From: Anita Gardner
Sent: 19 December 2017 14:15
To: Planning.Responses
Subject: FW: 1 in 100 hydraulic calcs for 1-4 Holm Oaks F/26/17/DOC

From: Paul Cann
Sent: 19 December 2017 11:44
To: Anita Gardner
Subject: RE: 1 in 100 hydraulic calcs for 1-4 Holm Oaks F/26/17/DOC

Paul,
Please see the attached additional information.
Is this now satisfactory for compliance with condition 3 of F/15/16/PL
Thanks
Anita

**Surface Water
Drainage Layout**

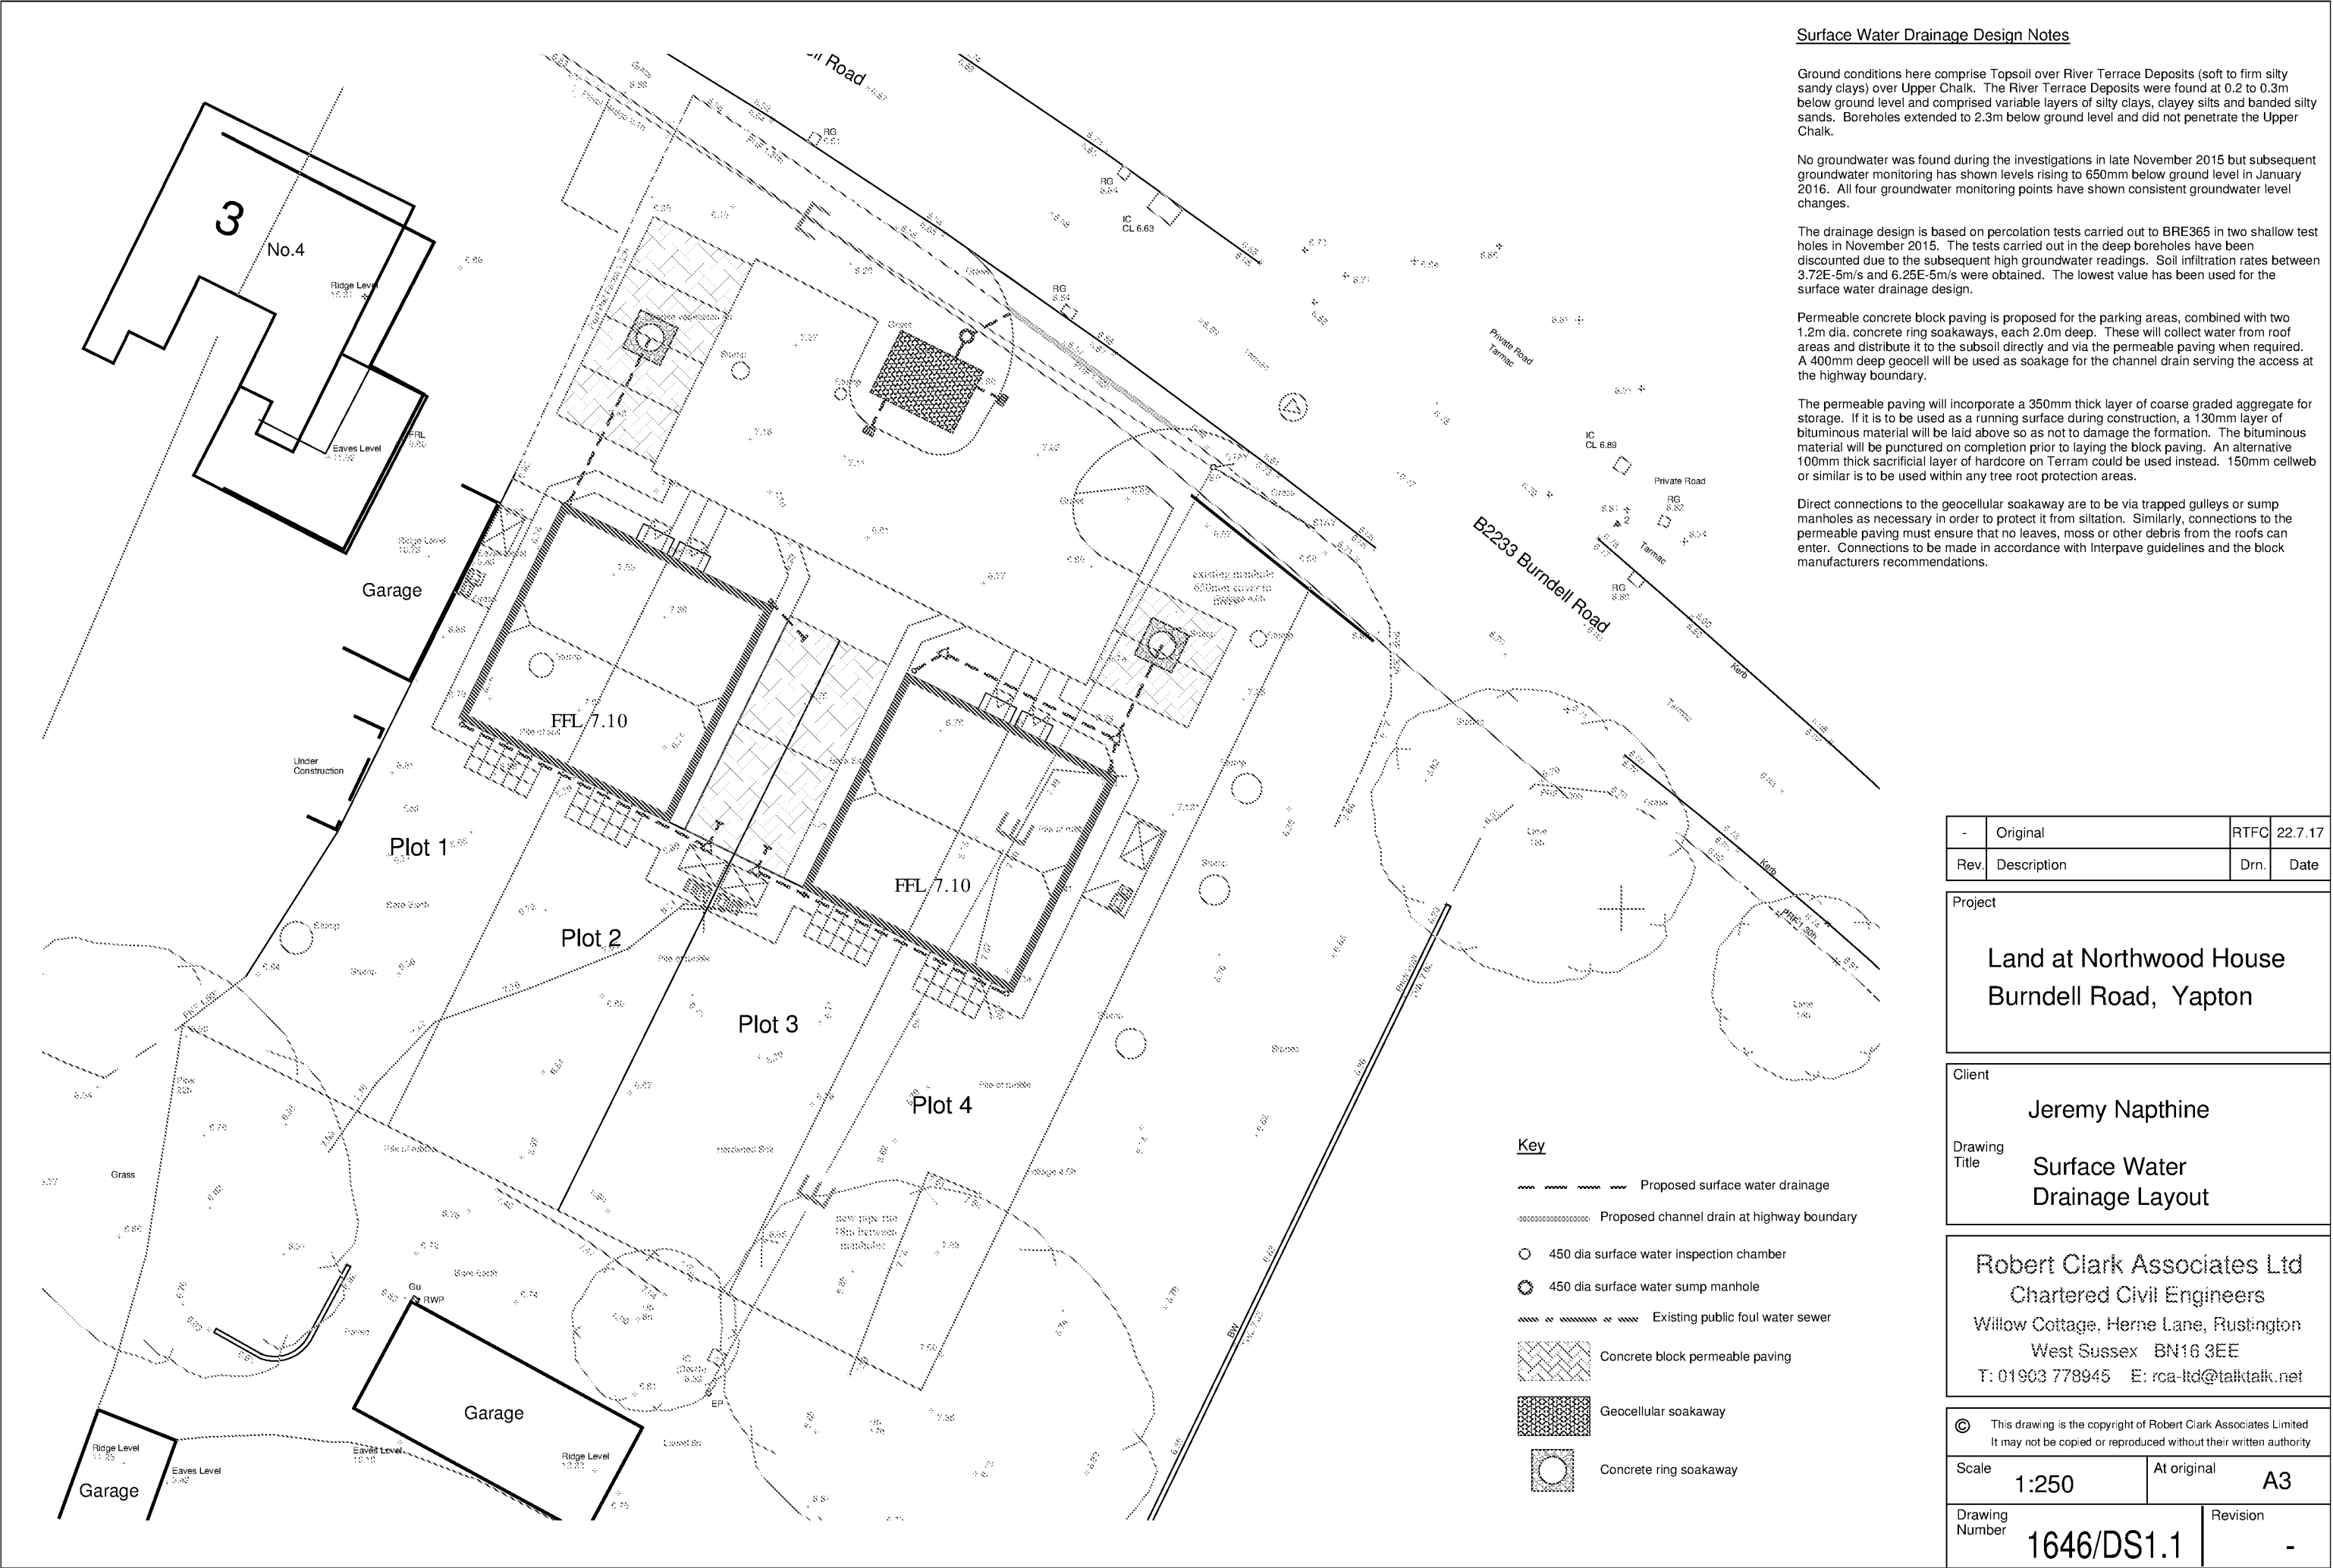
2. It appears that the current surface water drainage design deviates from the originally approved scheme. Also, what exists on site does not correspond to what is shown on the current drawings.

3. The three soakaways shown at the front of the site are not visible. The two at the rear in the rear gardens also do not exist in the positions shown, although there are two manhole covers visible in the rear of plots 1 and 3, which may suggest that their positions have been moved. A channel drain exists where the driveway meets the public highway. The applicant needs to clarify what has been built on site and update the drawings accordingly.

4. Show how the channel drain is connected into the system.
5. The scheme has a fundamental problem in that the proposals/calculations are partly utilising deep soakage and storage. The basis of the original scheme was to rely on shallow soakage/storage due to the high water table (650mm below ground level) and with also the better percolation rates being achieved at shallow depth. Therefore, a large proportion of the storage in the ring soakaways is not unusable in high groundwater conditions and cannot be taken account of in the calculations. If ring soakaways are to be used as a means of providing pipe connectivity/water distribution, then they need to be physically connected to shallow storage, where suitable capacity can be provided, and favourable percolation rates made use of. It should be noted that the potential ring soakaways in the rear of the properties may not have any

connection to shallow storage features and are therefore probably unable to accommodate the design storm. The hydraulic calculations will need to reflect the above (they currently do not).

6. An outflow/overflow is shown from the permeable paving. Why is this needed? Has it been built? The original scheme was to solely rely on shallow soakage/storage and therefore this type of connection would not be permitted. If the connection has been made, then it would have been made to the highway drain in Burndell Road. Did WSCC approve this? The notes on the drawing mention it discharging to a channel drain?, whilst item 1.9 of the Ambiantal report refers to a discharge to a ditch? Has the permeable paving been tanked as a result?

8. The drawing should clearly indicate the perimeter of the permeable paving (assumed green shaded area) -- add key.
9. Indicate finished surface levels for the permeable paving on the drawing, including levels on the channel drain. Has the permeable paving been laid with a flat formation level? -- indicate levels on drawing.

10. Pipe diameters/invert levels and gradients need to be specified for all pipes.
11. Catchpits required immediately upstream of all soakaway structures.
